**Our ref:** RA/2023/145899/06-L01  
**Your ref:** 2023/91441  
**Date:** 17 July 2025

**CHANGE OF USE AND ALTERATIONS TO FORMER CHURCH (B8-STORAGE) TO 9 RESIDENTIAL UNITS (C3) AND FORMATION OF CAR PARK (LISTED BUILDING WITHIN A CONSERVATION AREA).31 CHAPEL HILL, LINTHWAITE, HUDDERSFIELD, HD7 5NJ.**

Thank you for your re-consultation, received on 30 June 2025. We have reviewed the amended plans and are maintaining our objection.

Drawing:  
 Proposed  
 Site Sections

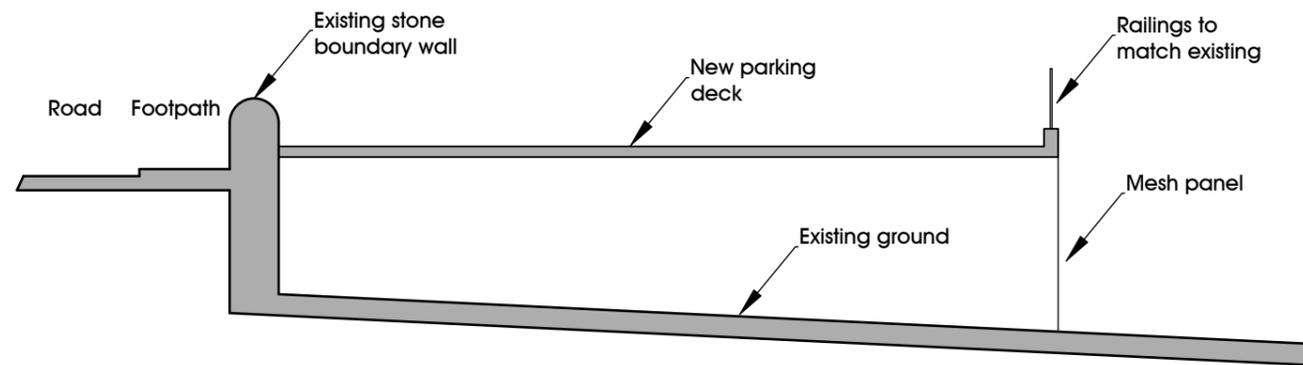
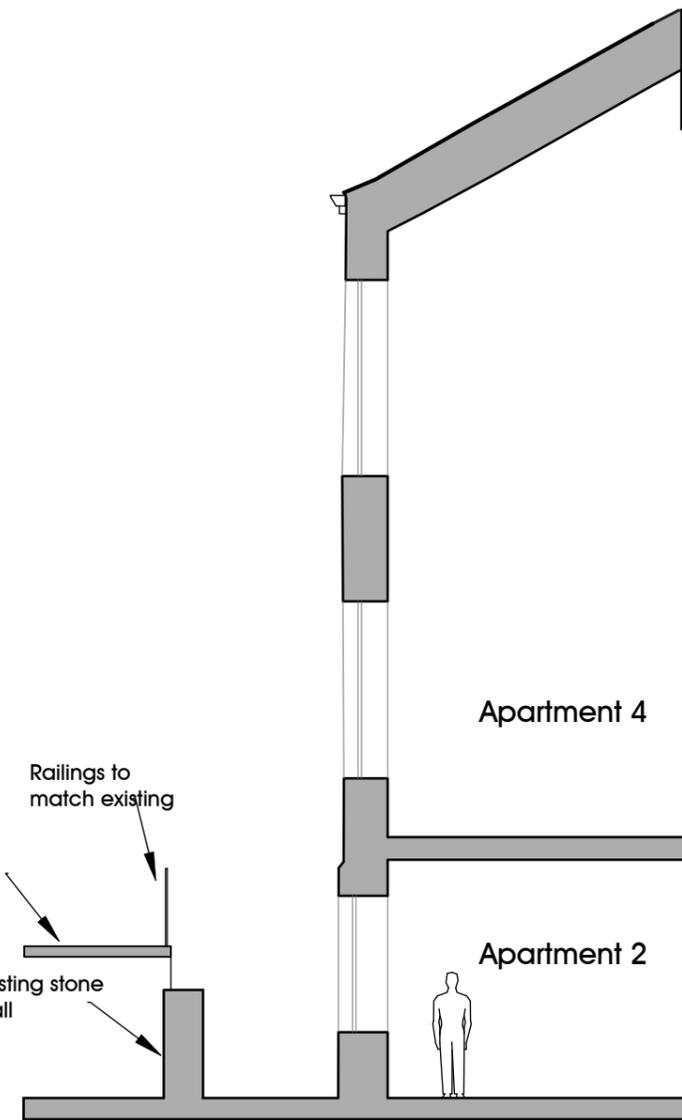
Whilst the new supporting drawing, referenced '23345-XX-XX-XX-DR-103 Foundations Plan', now clearly shows where foundations are proposed in relation to the culvert position it has not been demonstrated that all foundations within close proximity of the culvert will not impose additional loading on the structure. The applicant must provide evidence that the proposal will not impose additional loading on the culvert structure for us to find the proposals acceptable. The applicant should produce further section

drawings clarifying where loading from foundations either side of the culvert position may impact the culvert in addition to the sections already provided.

It does not appear that the site sections drawings, and plan view layout correspond in representation of size and scale of the proposal. The applicant will need to ensure that the cross sections and plans clearly correspond to each other.

The recent information submitted doesn't address our previous objection relating to access to the culvert for maintenance. The applicant must demonstrate that unrestricted access to the culvert will be maintained despite the proposals. This is necessary to ensure any required maintenance works to the structure can be carried out.

The applicant may potentially consider whether it is possible to provide car parking at existing ground level without the need for a deck. The applicant will still be required to show that unrestricted access to the culvert can be maintained, and that the structural integrity of the culvert will not be compromised by the proposals.
